Exhibit 9 - Public Comments

From: Christa Friedrich
To: [Lauren Anderson](#)
Subject: File No. CAO18-003, Property located at 8114 West Mercer Way
Date: Wednesday, July 11, 2018 3:37:23 PM

Re: File No.: CAO18-003

Figure 4. Site Plan Showing Proposed Buffer Reduction and Addition Areas

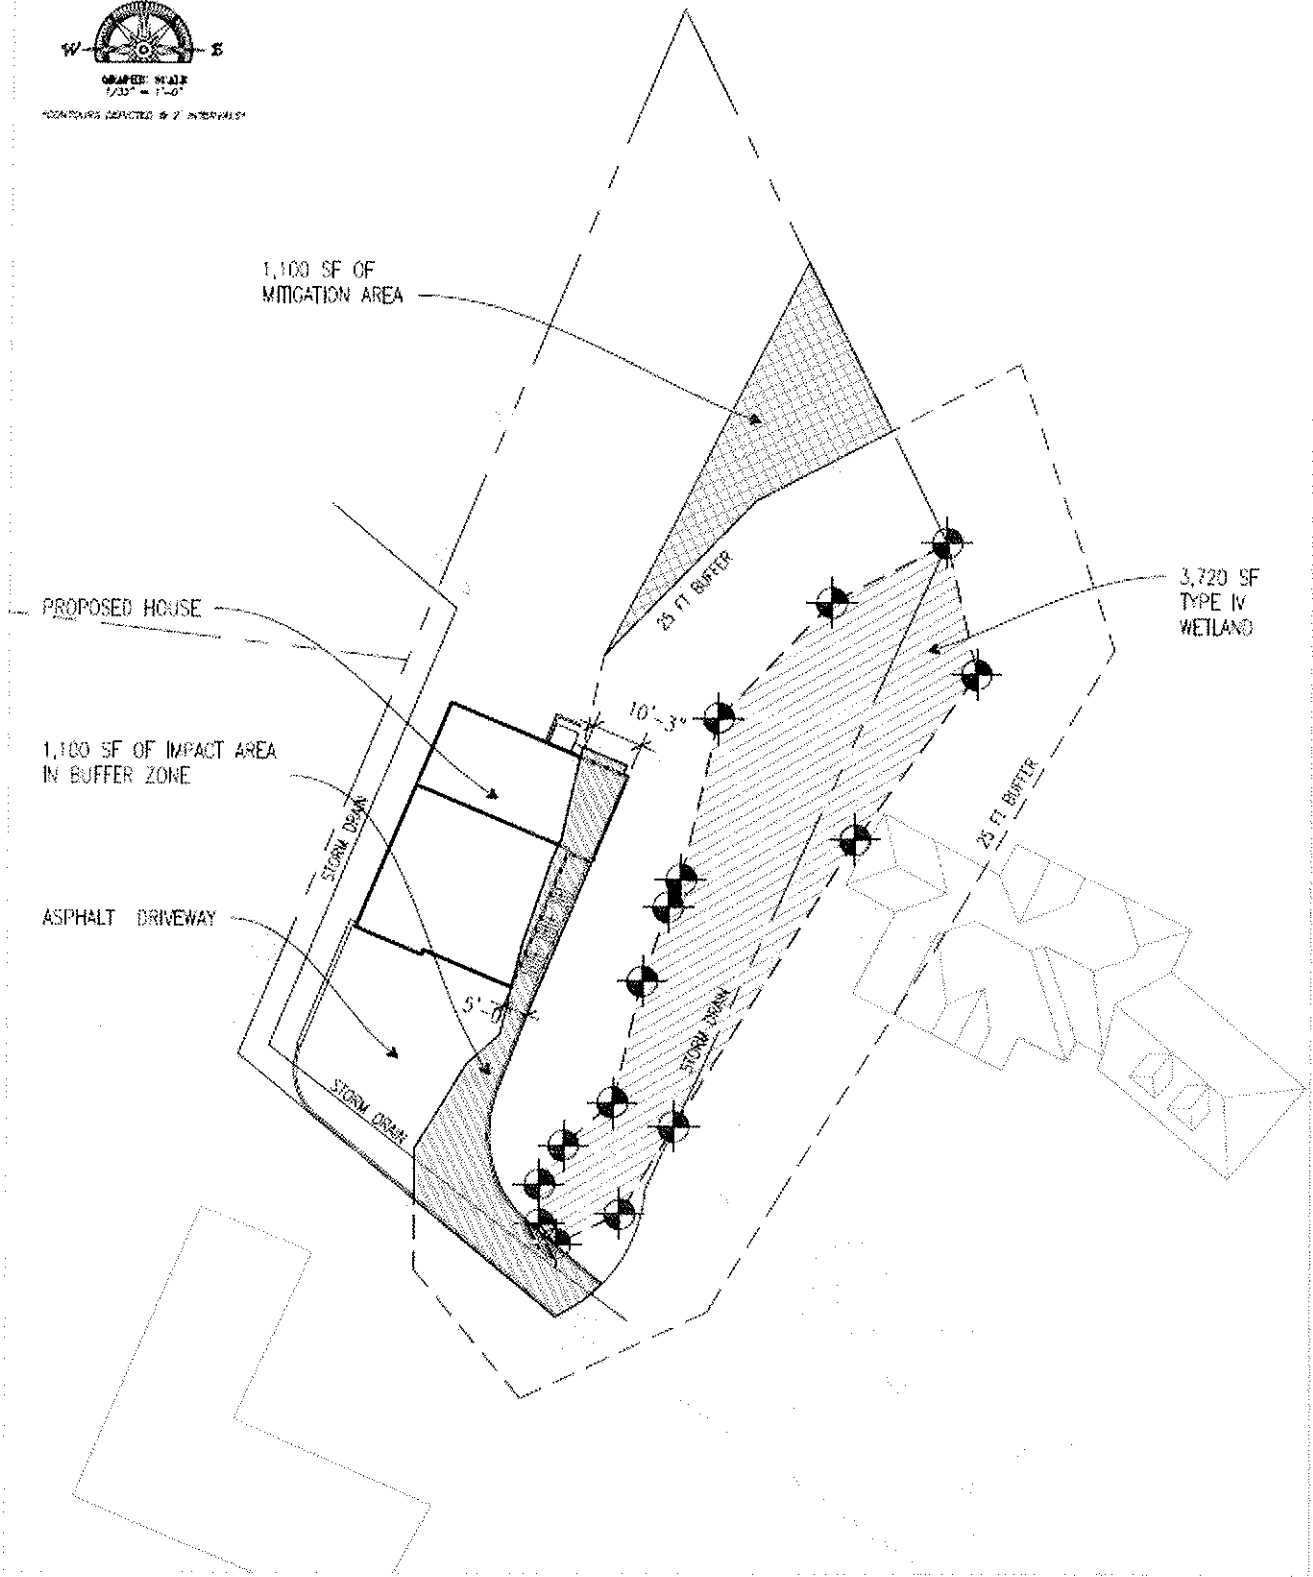
Page 1 indicates the residence is proposed to be within 15 to 20 feet of the wetland and that the driveway is proposed to be within the 25 foot wetland buffer. The site plan (Figure 4) actually shows that the residence will be within 14 feet 9 inches of the wetland. MIMC 19.07.080.C does not allow the wetland to be reduced or averaged below the minimum buffer of 25 feet. Applicant should be required to meet the code and provide a minimum 25 foot buffer from the residence.

MIMC 19.07.030.A (6) does allow for driveways within a wetland buffer. However, the driveway is directly abutting the wetland (which will indirectly impact the wetland) and there is not discussion of if there is an alternative with less impact to the wetland or wetland buffer. In addition a wetland impact analysis that discusses the projects direct and indirect wetland impacts is not included in the mitigation plan. The driveway runoff, clearing of vegetation up to the edge of the wetland and construction of the residence abutting the reduced wetland buffer will all have direct and indirect impacts to the wetland system. The applicant should be required to identify the types of vegetation and conditions of the impact areas, proposed
